**PLAN REVIEW SHEET**

**Date: November 17, 2020**

**Petition #: RZP 2020-150**

**Request: UR-2 (CD)**

SCHEMATIC
SITE PLAN

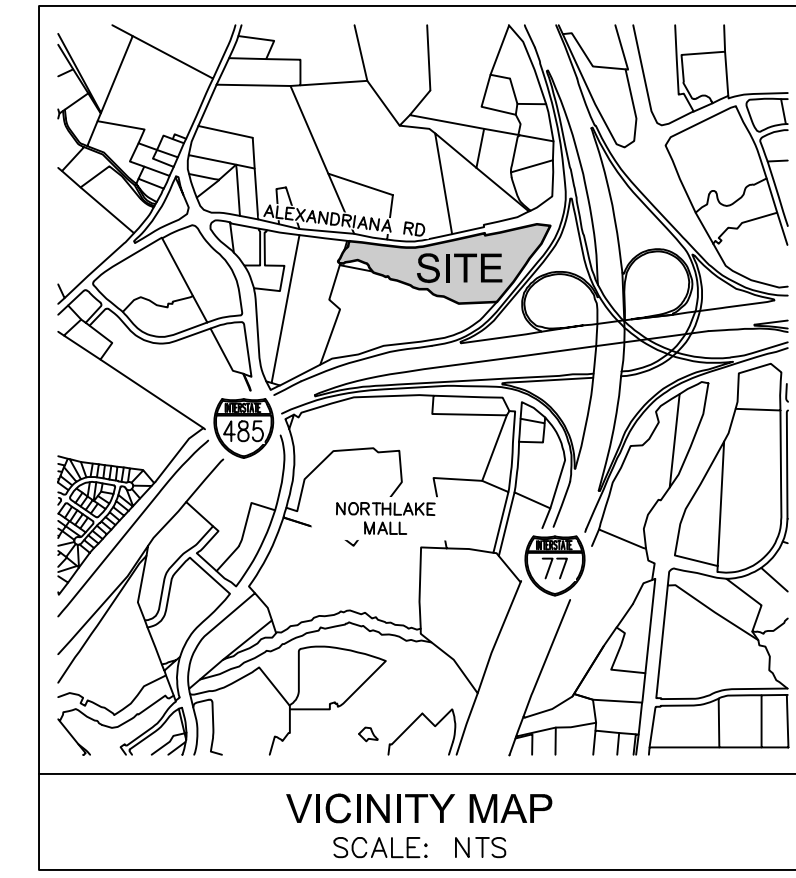
The site is located along CATS local bus route #99 on Alexandriana Road. CATS requests the petitioner to construct a new ADA compliant bus waiting pad per Land Development Standard 60.03A along Alexandriana Road, generally in the middle area of the development. The final location of the pad will be coordinated with the developer through the permitting process.
